Date: 9/25/2023

Permit #: 8719

Project Name: Christopher Vellon

Address: 39 Hartford Ln Fuquay-Varina – North Carolina, 27526

REVISION: **A** PAGE NUMBER: **PV3**

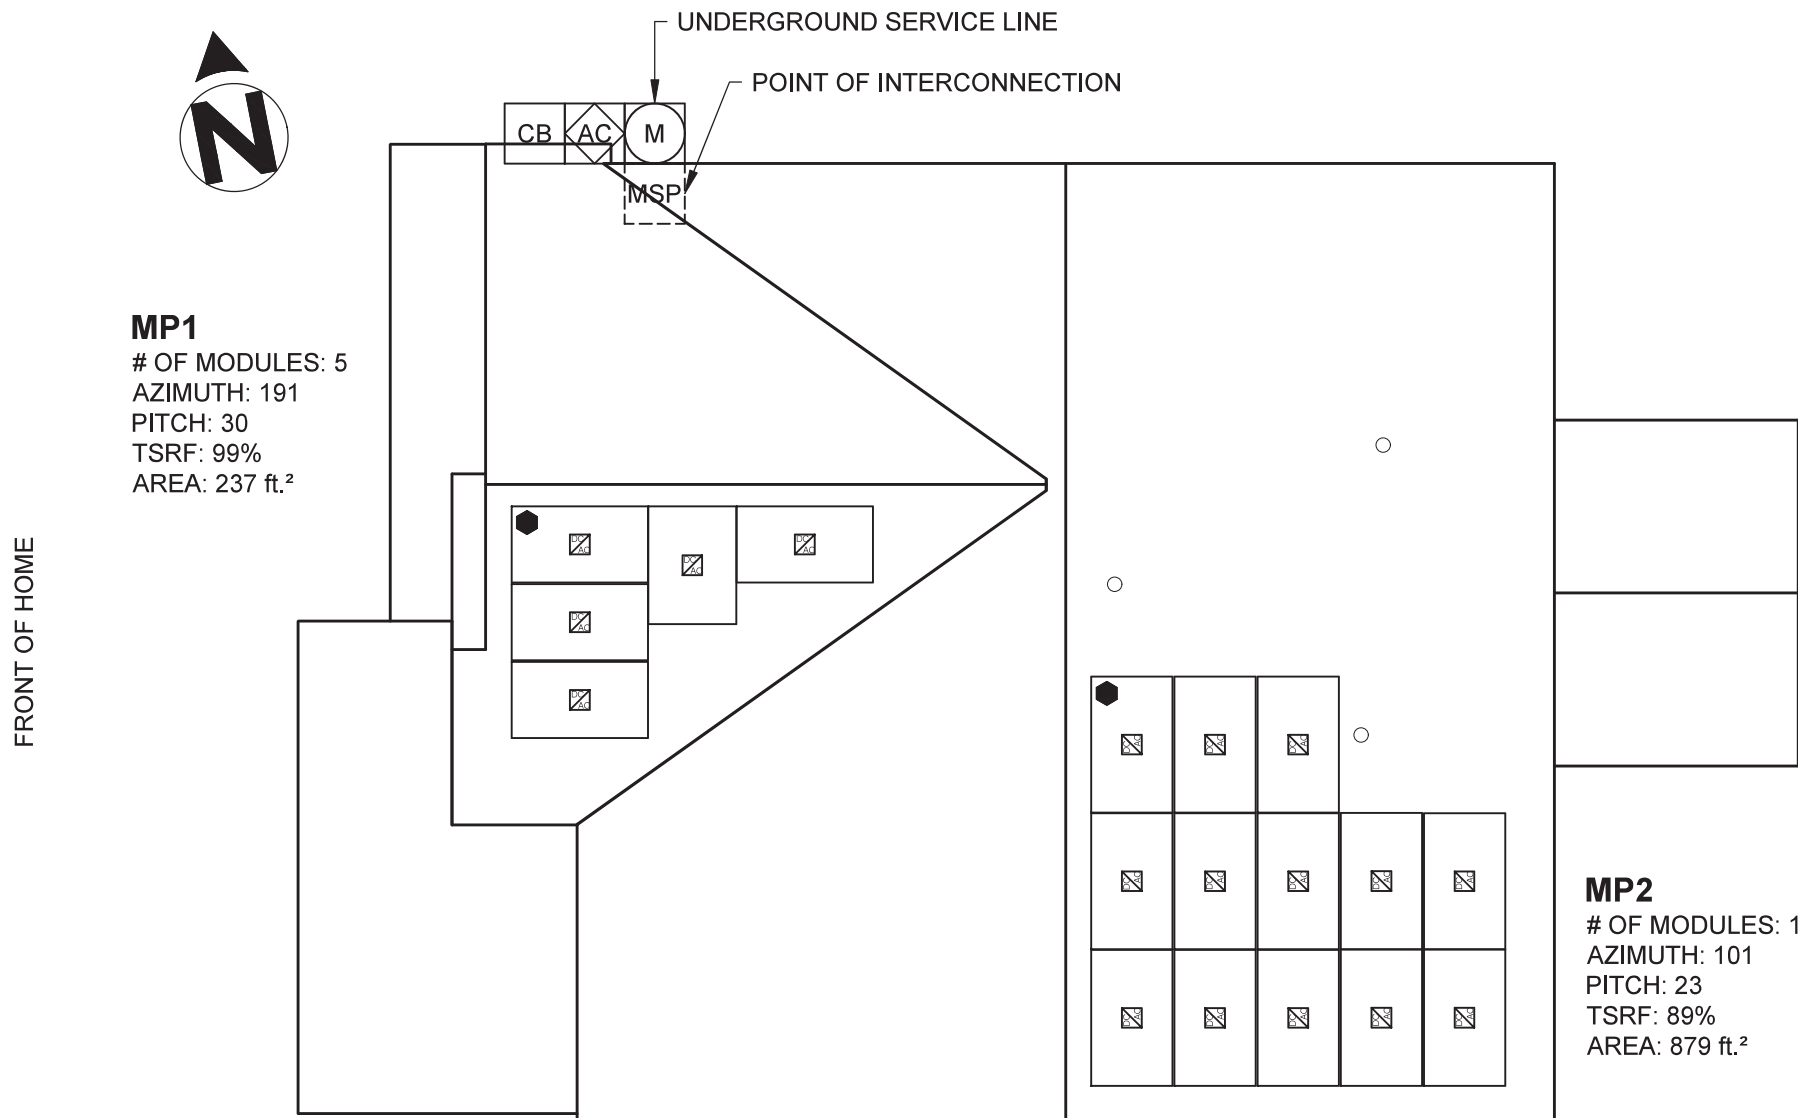
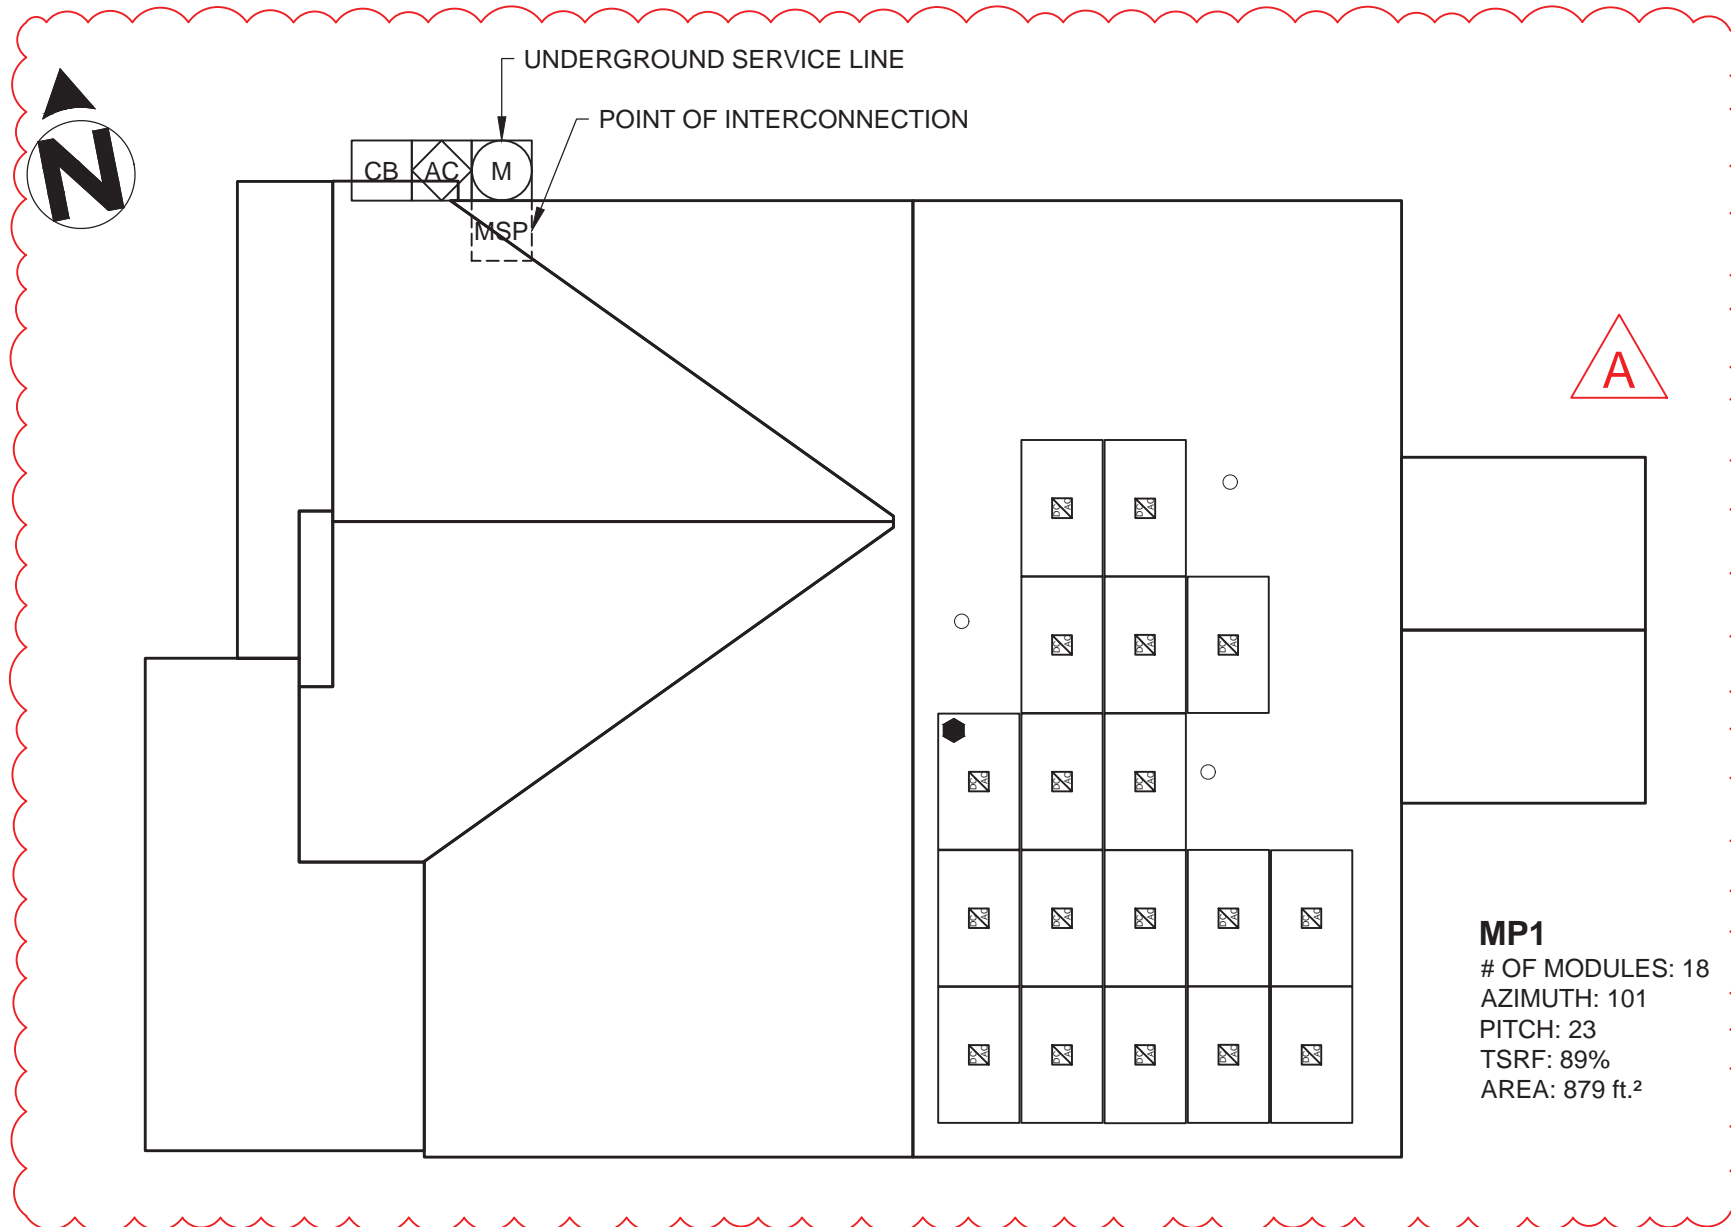
Updated plans to show all panels on the back of the home per the HOA's requirements.
